Please ask for: Mrs D Johnson
Email: daun.johnson@arun.gov.uk
Telephone: 01903 737762
Our Ref: LU/136/21/PL
Your Ref:
Date: 19th May 2021

Application for Planning Permission

Development: Second & third storey extensions to existing care home to provide 14 No. new residential care rooms. This application may affect the setting of listed building, affects the character & appearance of the East Street Conservation Area & is in CIL Zone 4 (Zero Rated) as other development.

Location: Mewsbrook House 59 East Street Littlehampton BN17 6AU

DRAWING TITLE: EXISTING FIRST FLOOR PLAN

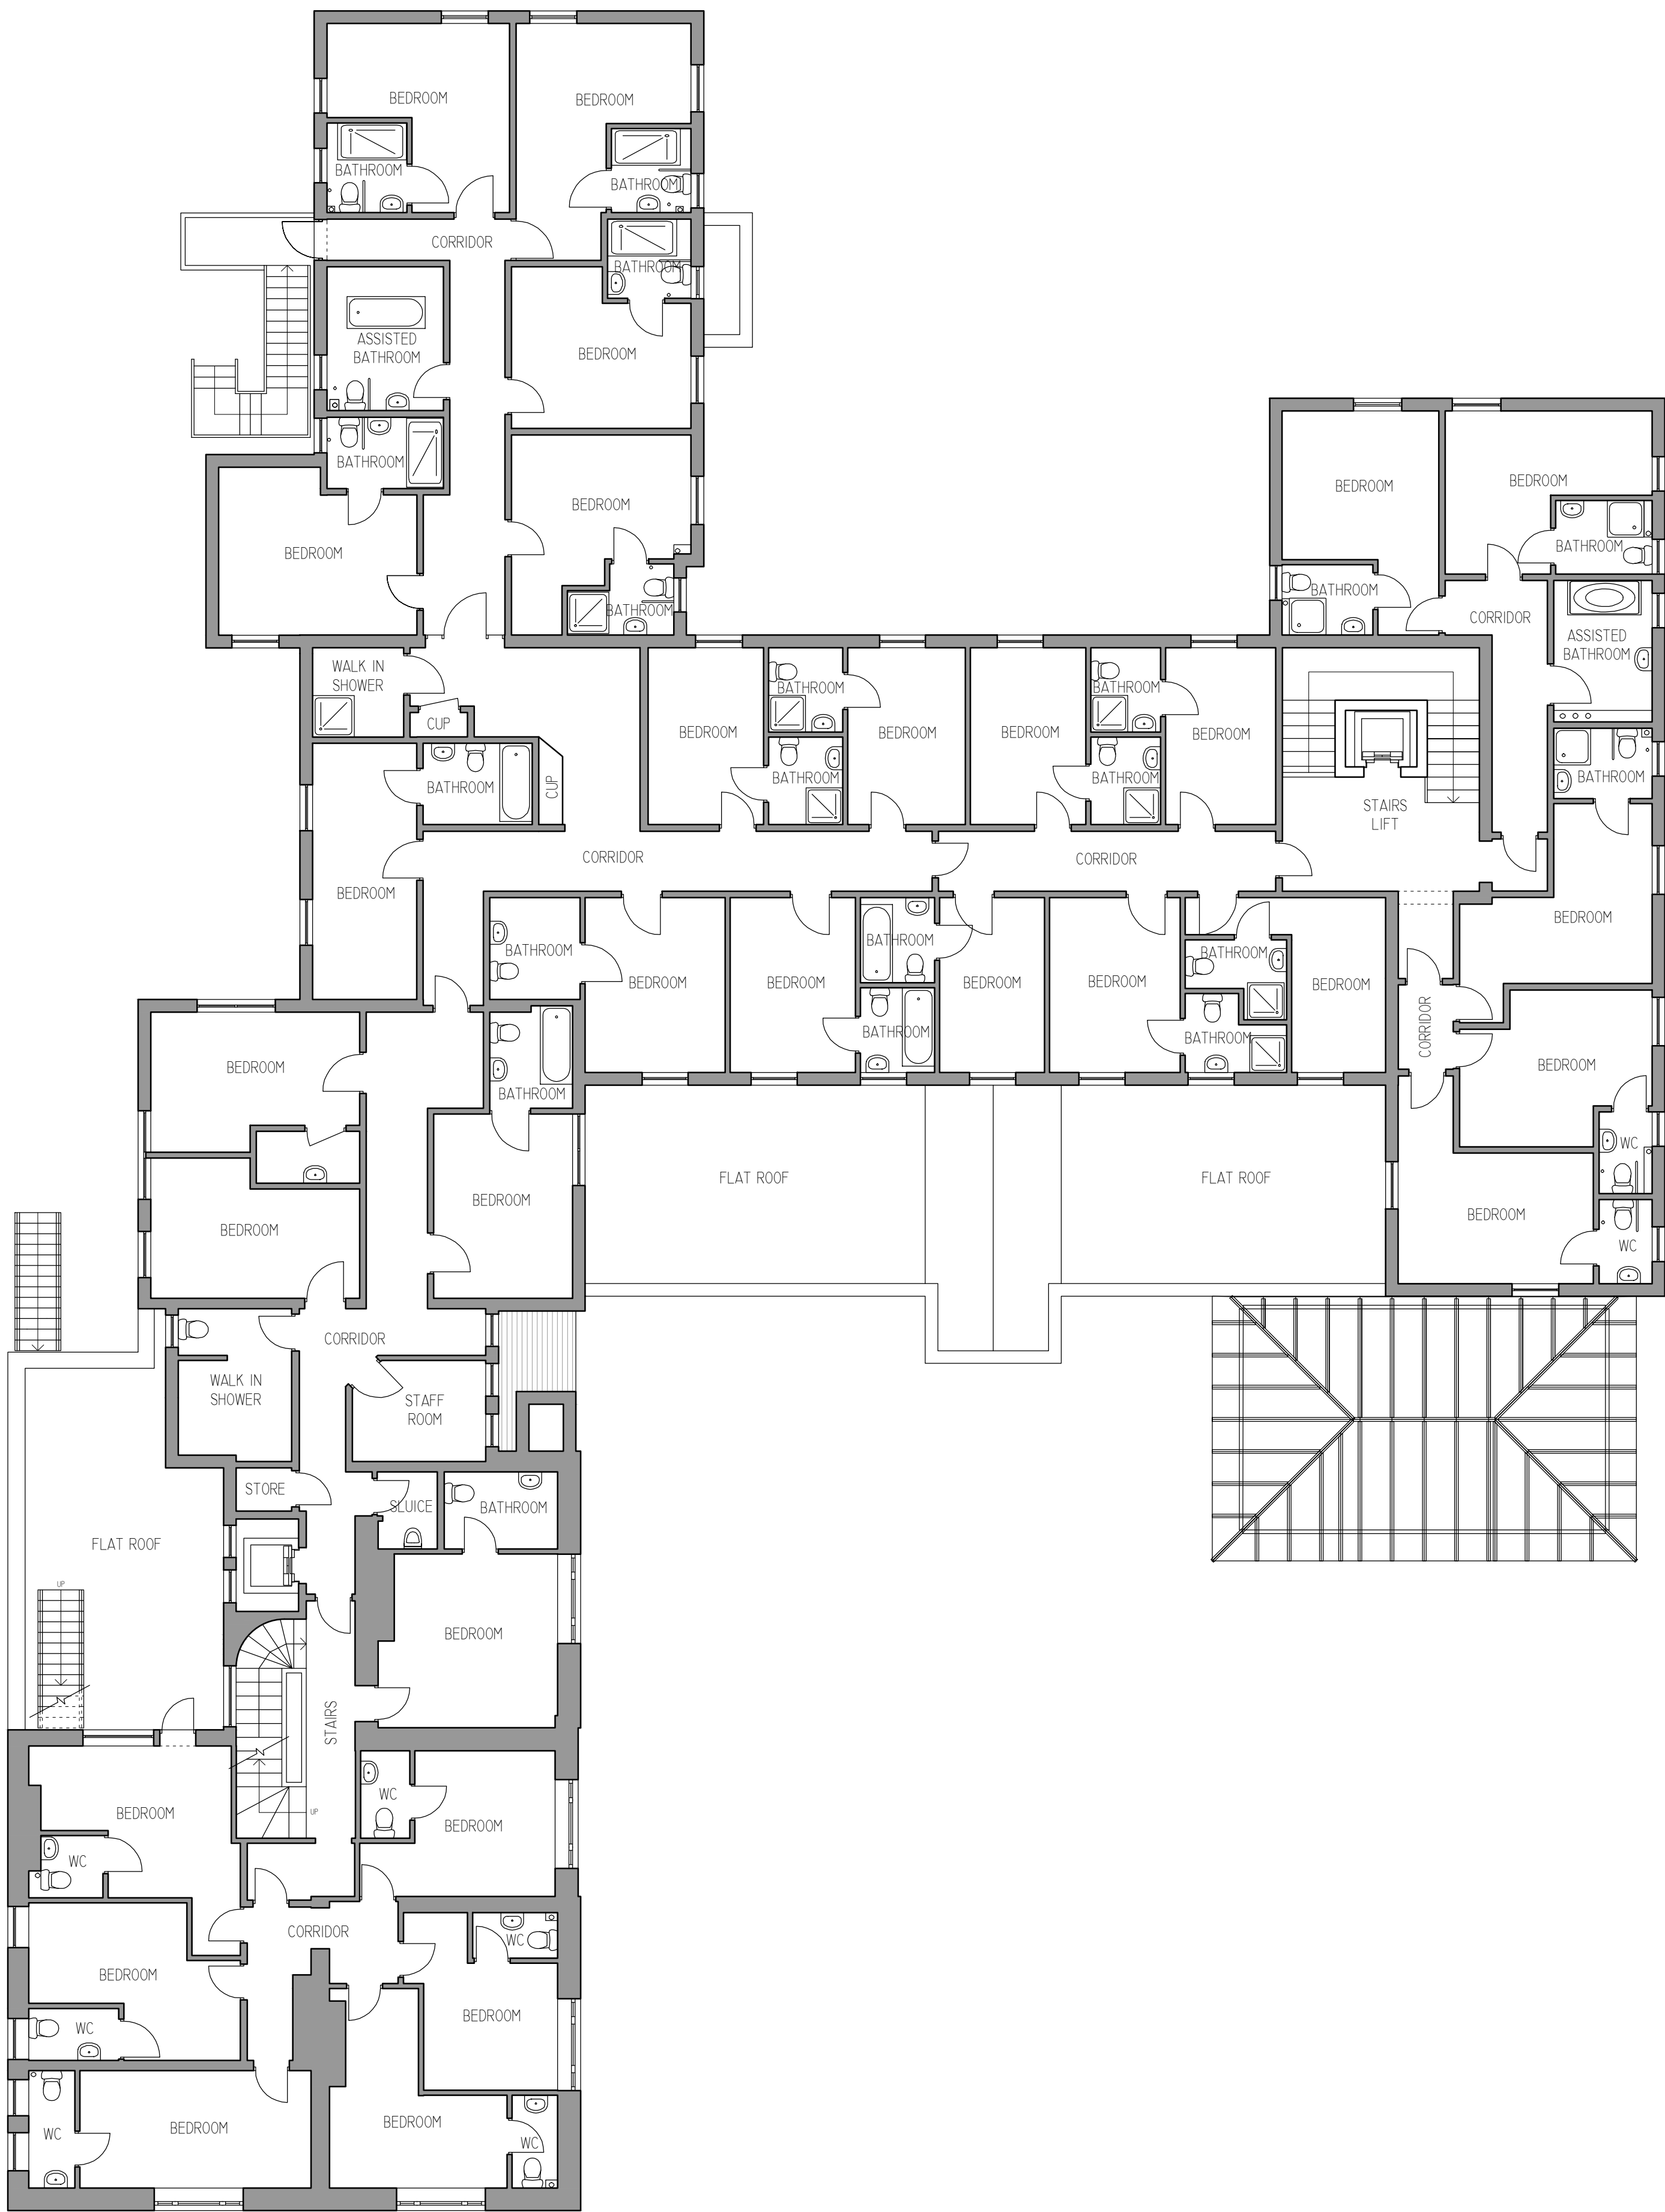
The existing and proposed West elevation B and first floor plan do not accord. Please amend accordingly.

The existing and proposed West elevation A and first floor do not accord. Please amend accordingly.

DRAWING TITLE: EXISTING GROUND FLOOR PLAN

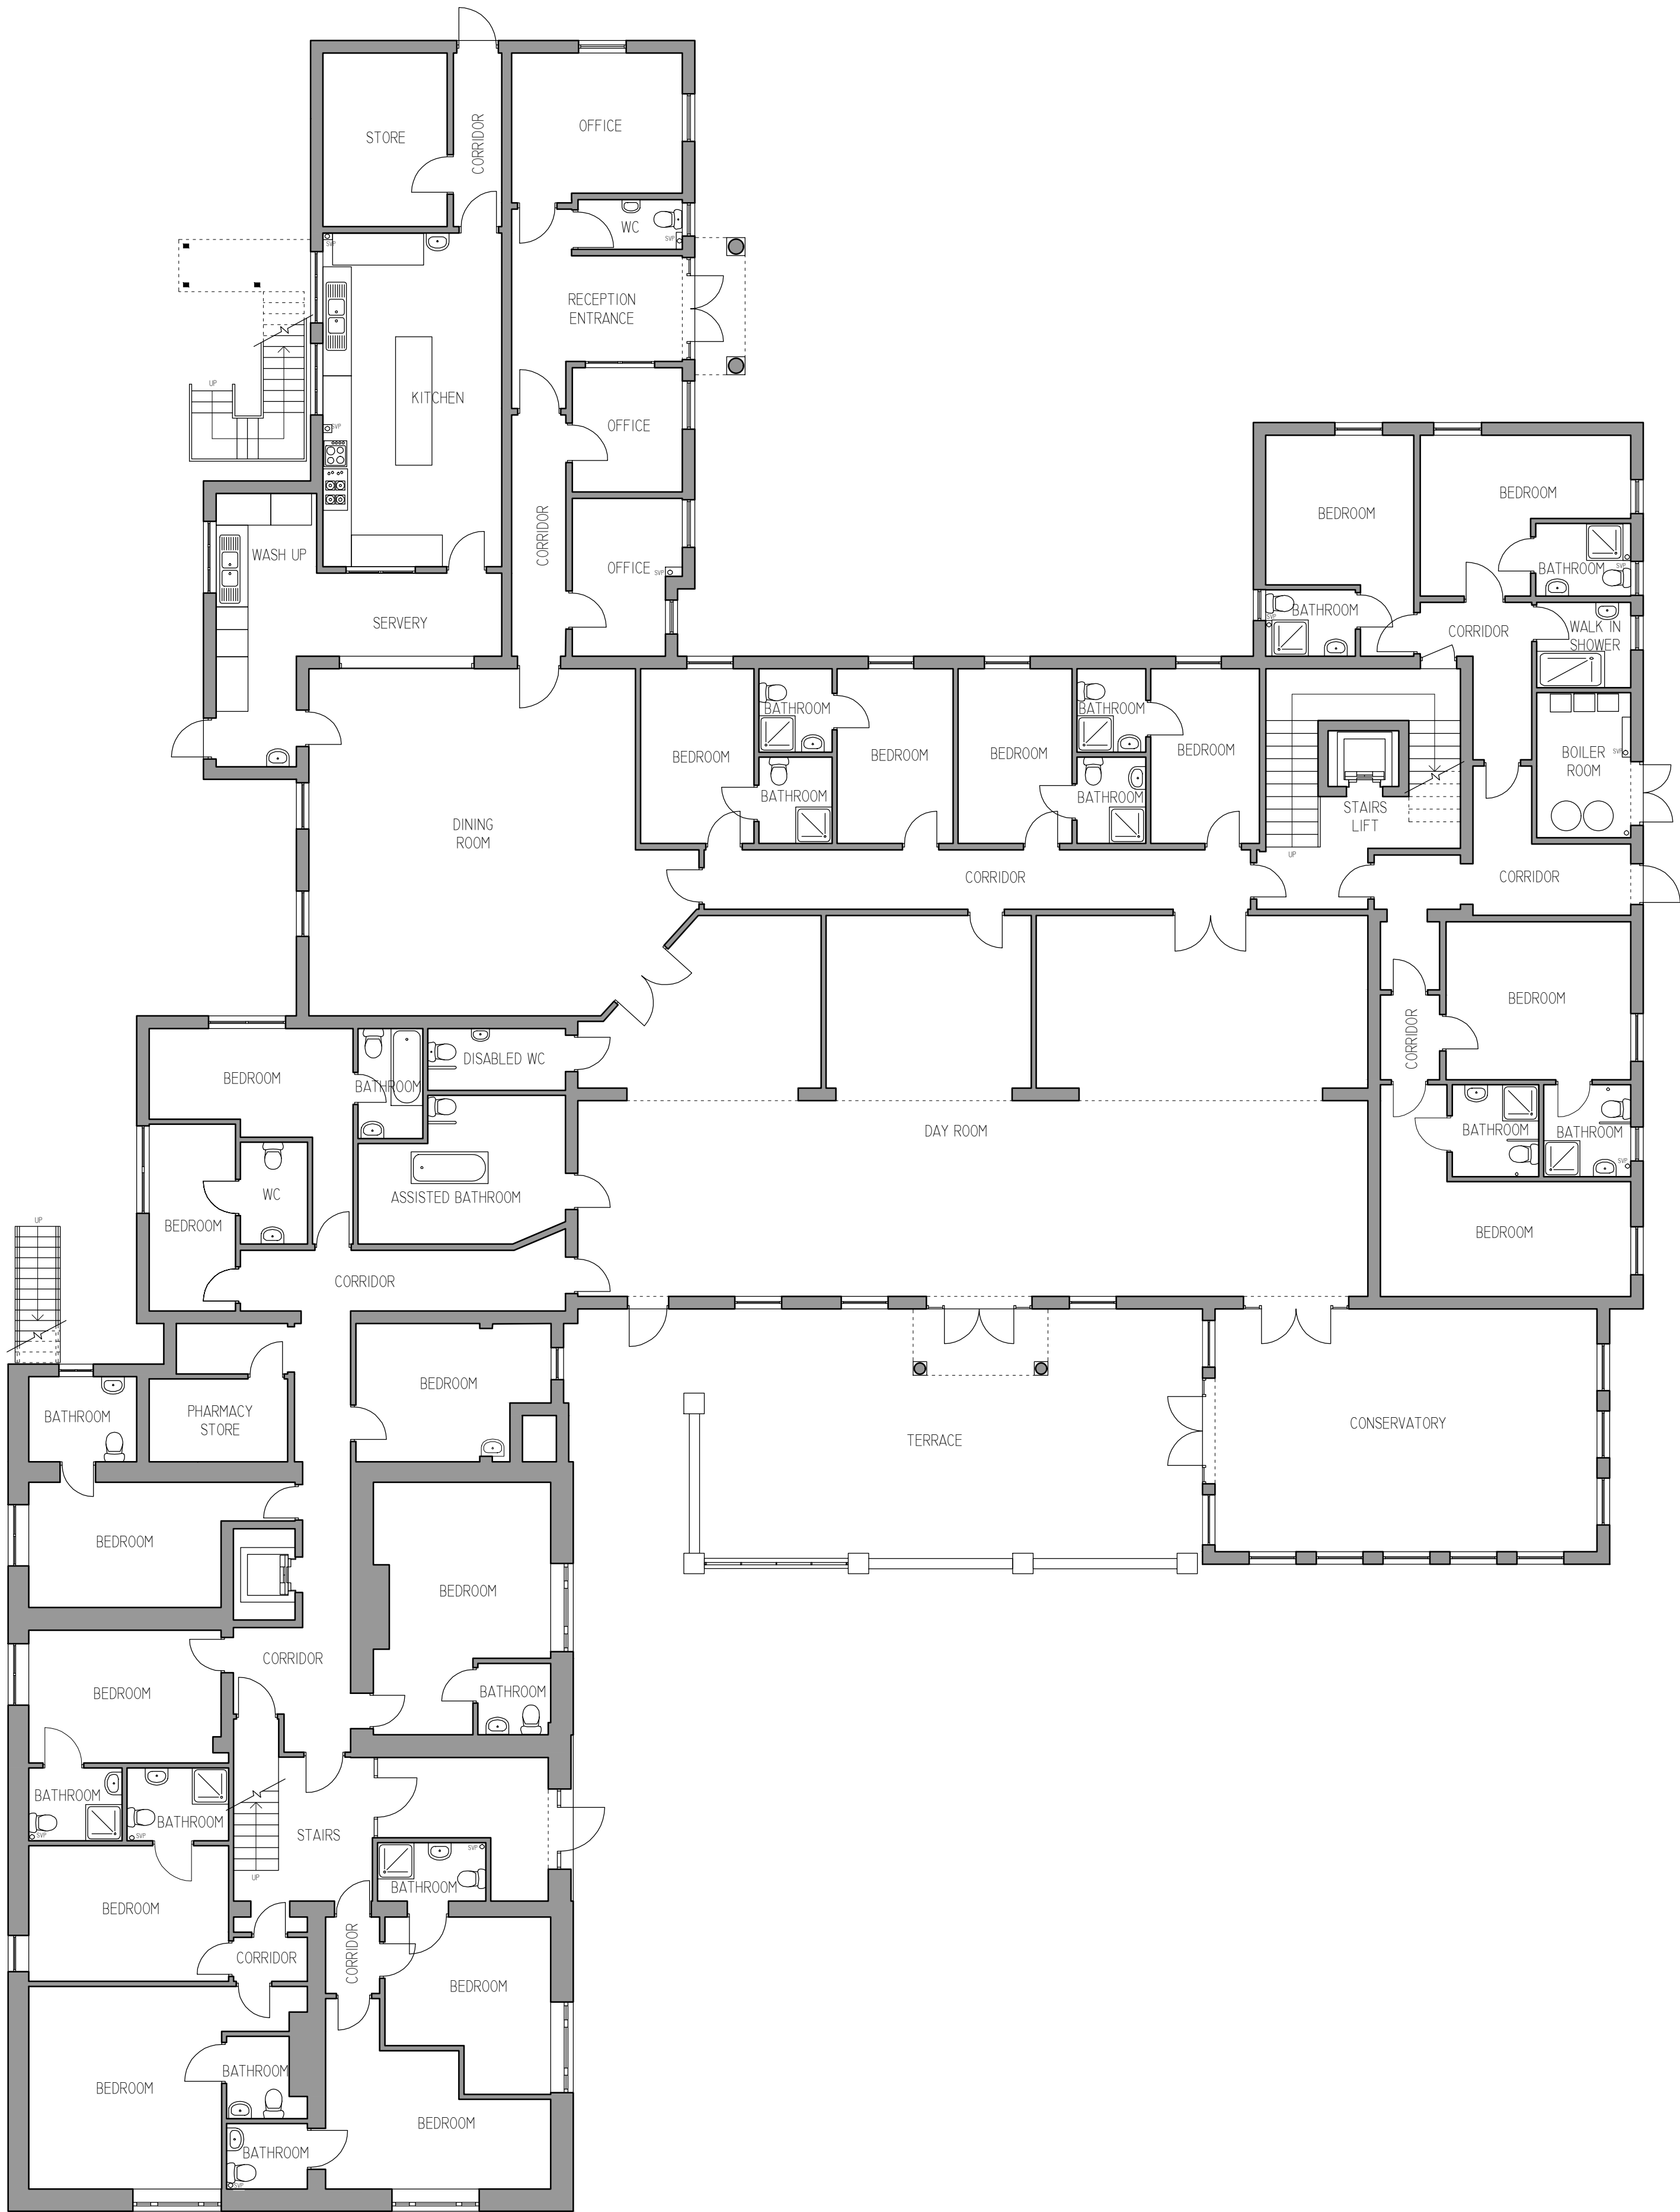
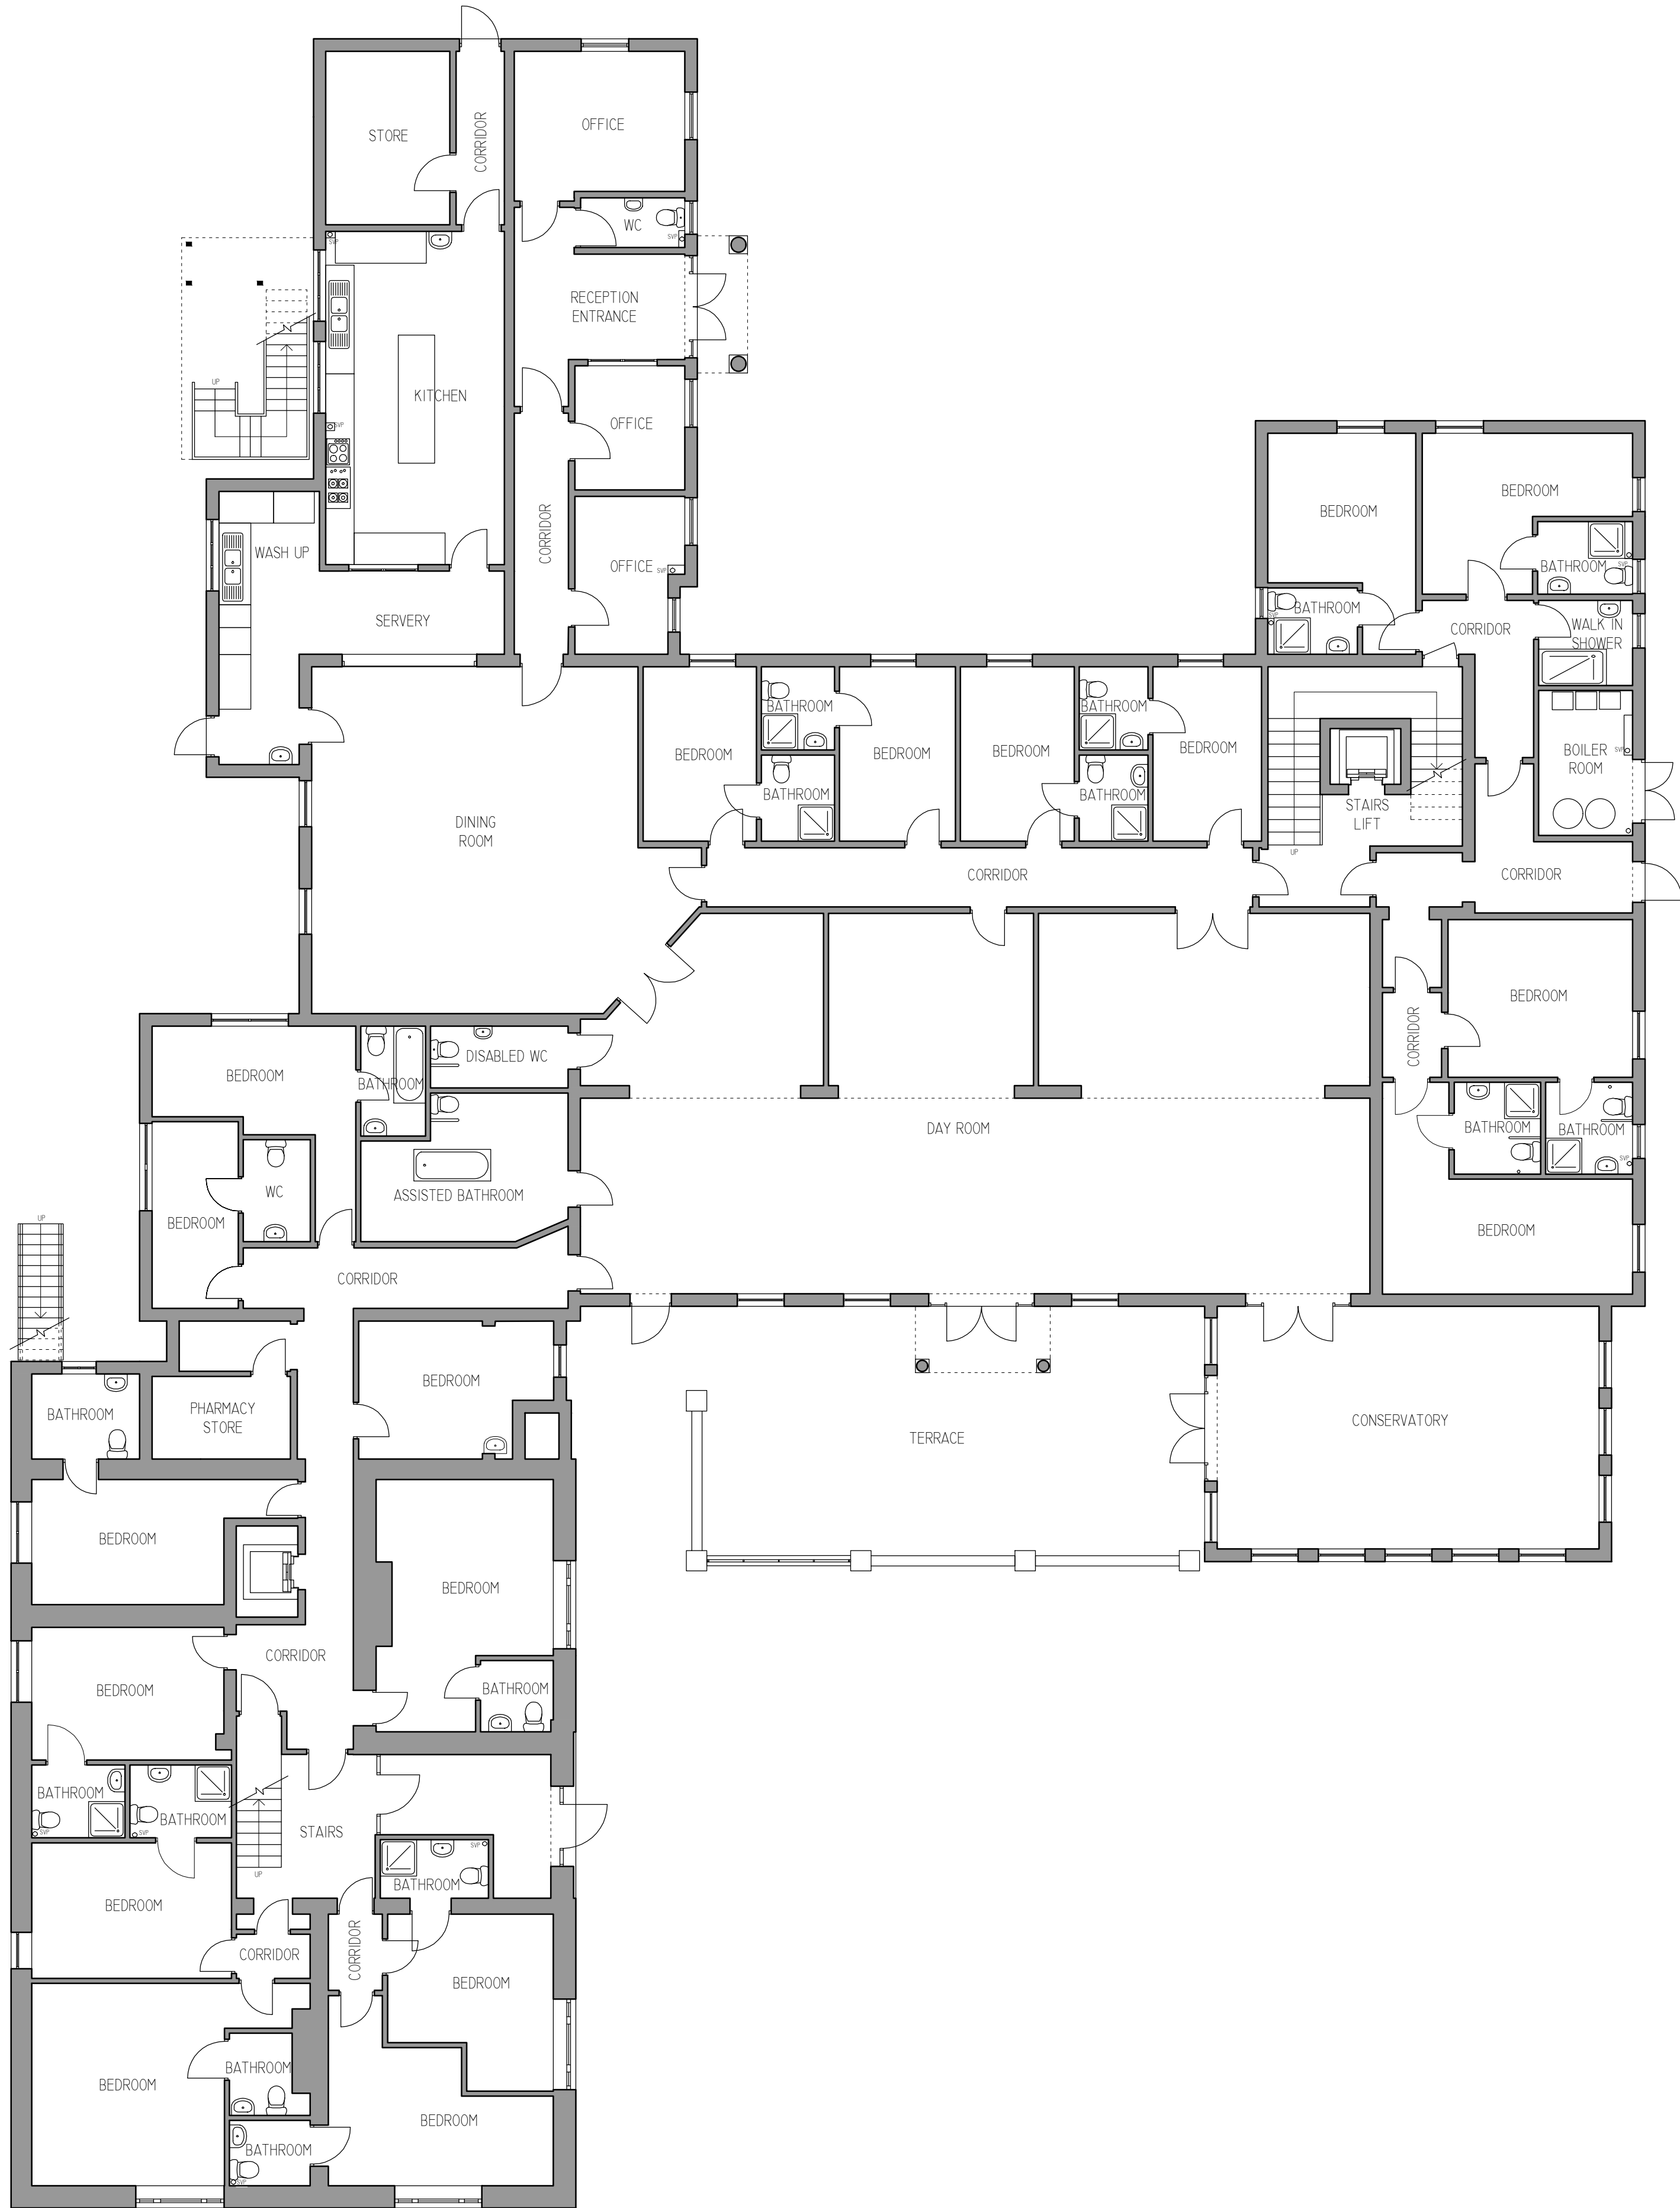
The existing and proposed East elevation and ground floor plan do not accord. Please amend accordingly.

the existing and proposed South elevation and ground floor plan do not accord. Please amend accordingly.

The existing and proposed West elevation A and ground floor plan do not accord. Please amend accordingly.
